Interested Party reference
number
20035951

Deadline 2 Written Representation - Draft Development Control Order

I wish to make the following comments regarding the Draft Development Control Order, document reference PDA-003 submitted by the applicant at Procedural Deadline A.

DRAWING TITLE
Access and Rights of Way Plans
Sheet 2 of 6

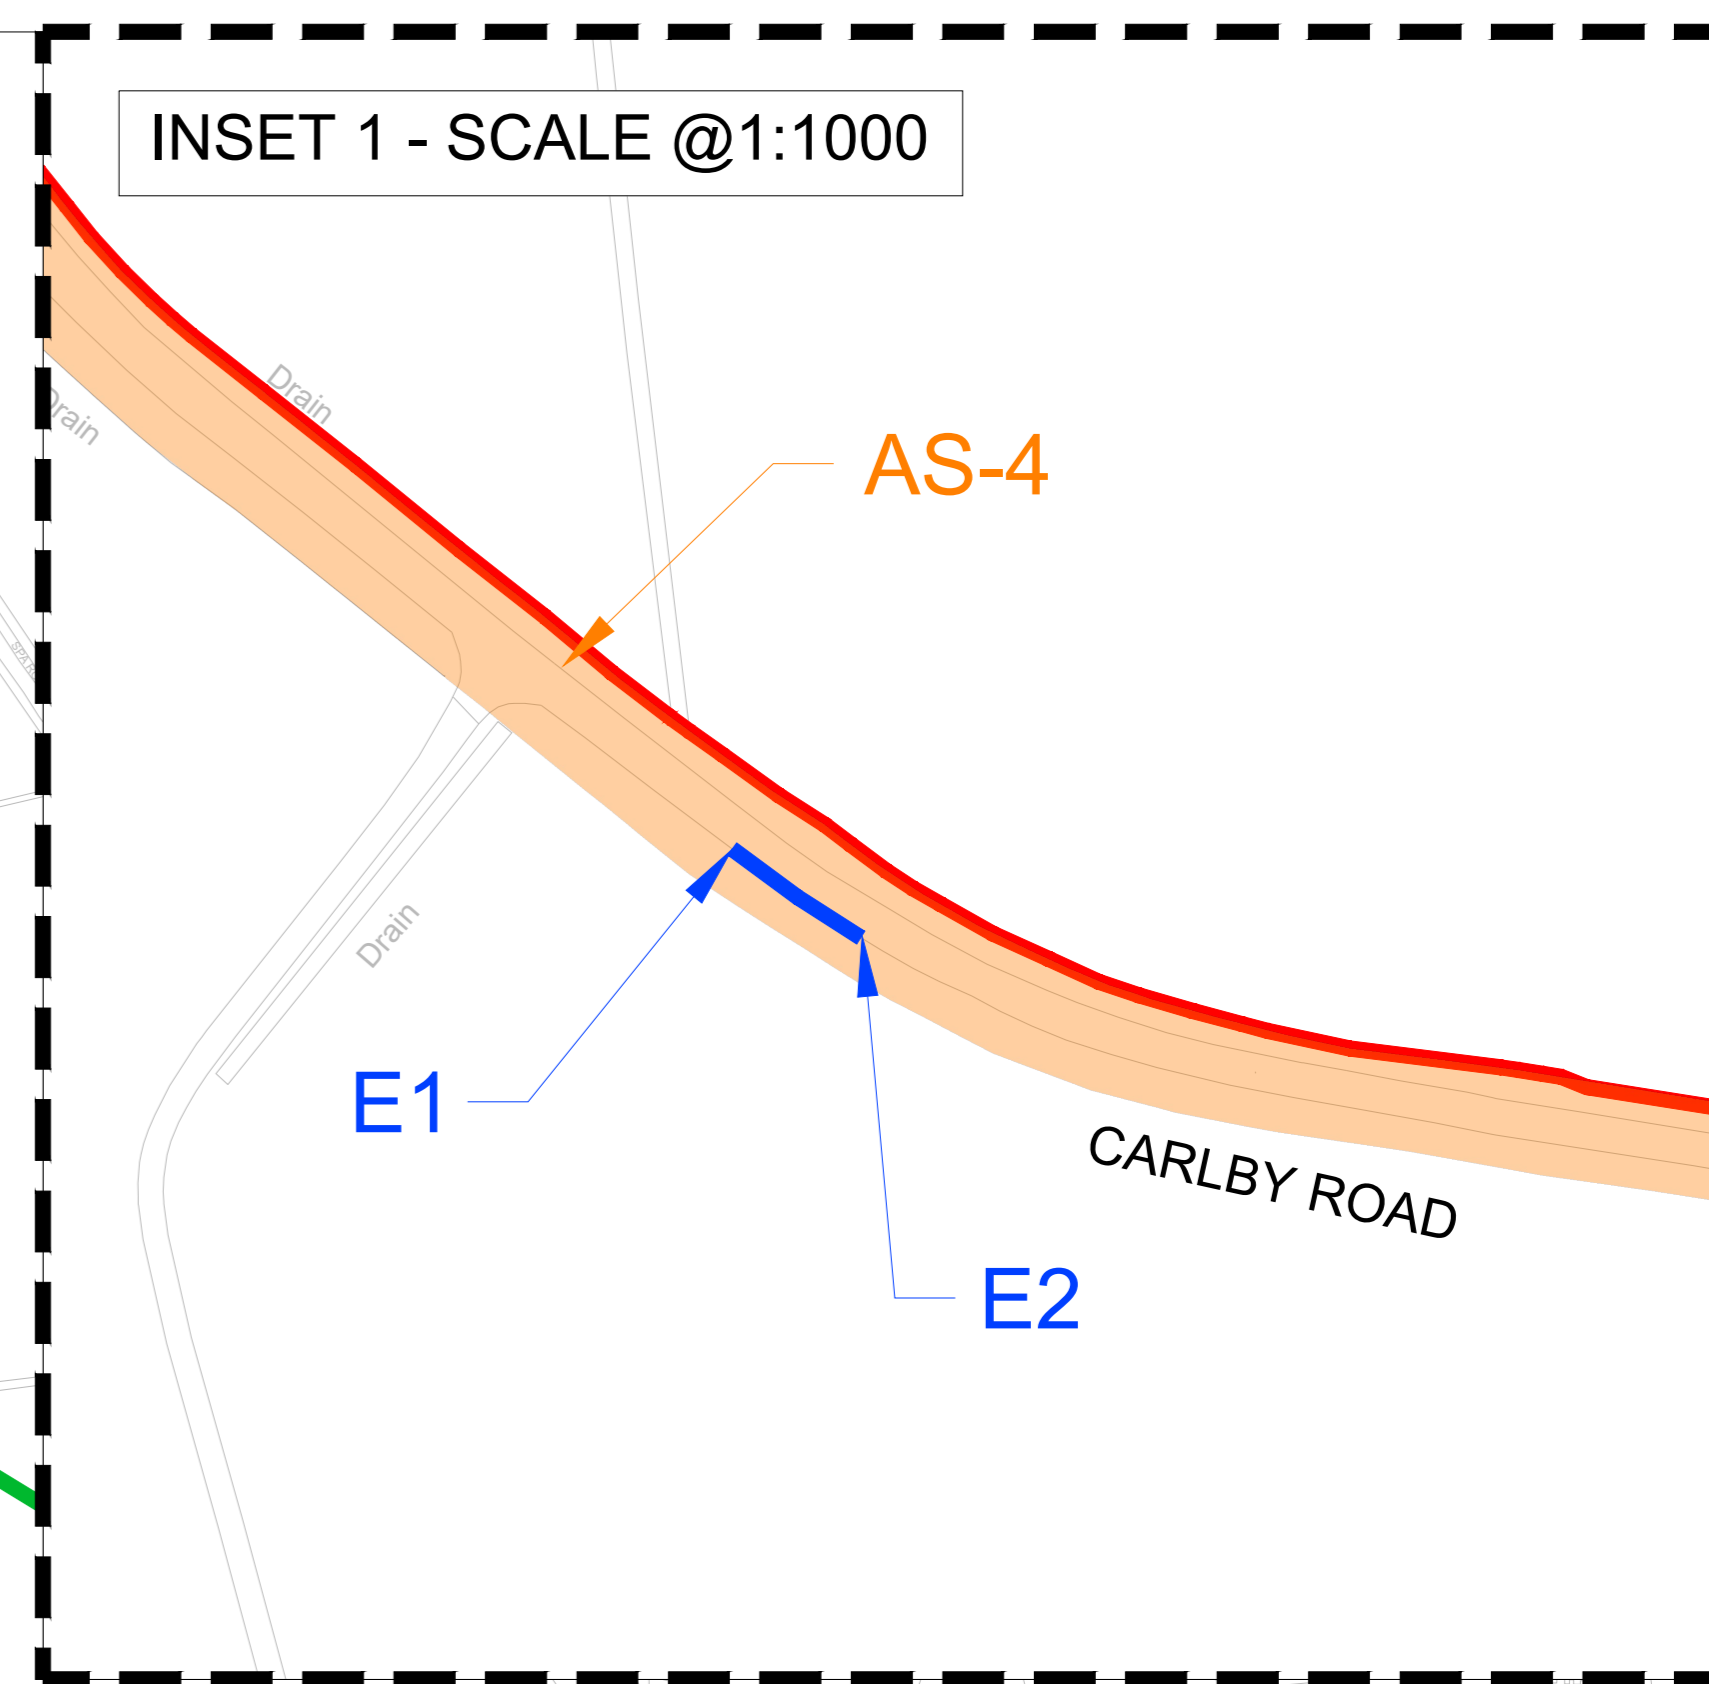
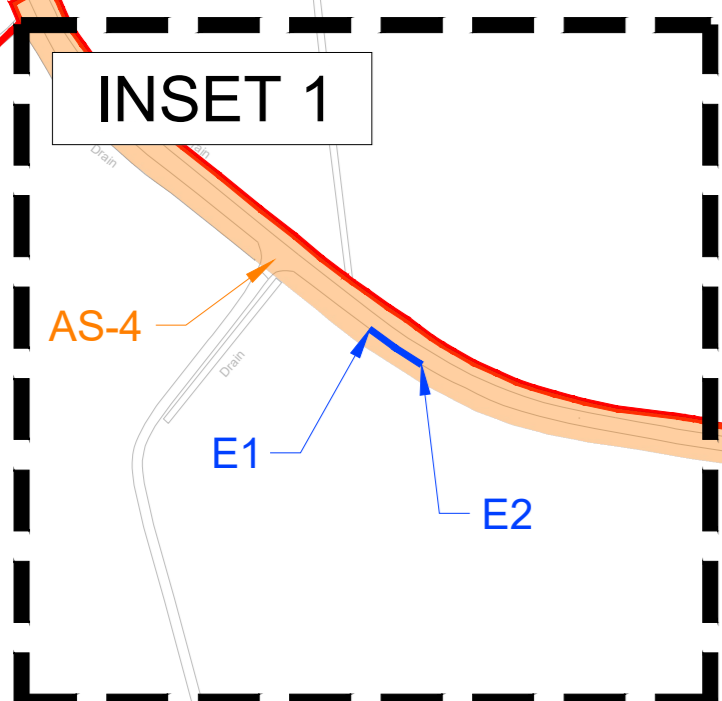
The phrase "public walkway" is used three times within this schedule. It doesn't appear that this phrase is defined either in the dDCO or other legislation.

In the case of SW-6 (Pickworth Road), as an example, the road has no pavement so it can't be that "public walkway" is intended to mean pavement.

Suggest that all instances of "public walkway" are replaced by "highway".
